Response to Planning Application

From: Arun District Council Leisure & Greenspace

Application ref: AL/143/24/RES

Description: Approval of reserved matters following outline consent AL/129/21/OUT for 93 No. residential dwellings with associated parking, landscaping, open space (including play areas), infrastructure and works. This application is in CIL Zone 3 and is CIL Liable as new dwellings.

Title: Planting Plans Sheet 3

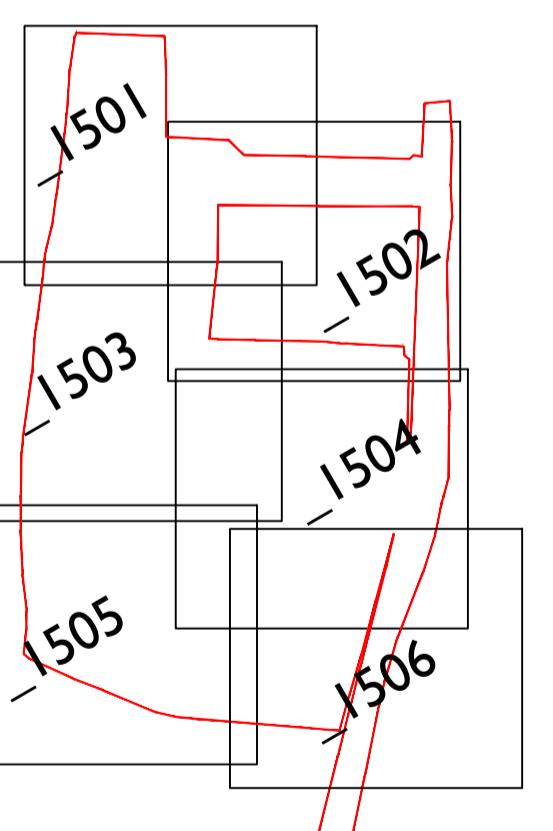
Soft landscape detail has been provided within GLS_020_170_P1_1300 Rev E		General Arrangement
Substitute Plan A	23-04-25	Planting Plan Sheet 1 GLS_020_170_P1_1501 Rev
Substitute Plan A	23-04-25	Planting Plan sheet 2 GLS_020_170_P1_1502 Rev
Substitute Plan A	23-04-25	Planting Plan Sheet 3 GLS_020_170_P1_1503 Rev
Substitute Plan A	23-04-25	Planting Plan Sheet 4 GLS_020_170_P1_1504 Rev
Substitute Plan A	23-04-25	Planting Plan Sheet 5 GLS_020_170_P1_1505 Rev
Substitute Plan A	23-04-25	Planting Plan Sheet 6 GLS_020_170_P1_1506 Rev

The information provided would appear appropriate for location in species choice and planting composition. The planting has been detailed in plan form and has included species mix, quantities, planting densities and size at time of planting. The planting proposals detail a scheme of native and ornamental varieties which each have value in location either for biodiversity purposes or ornamental habit, softening and screening.
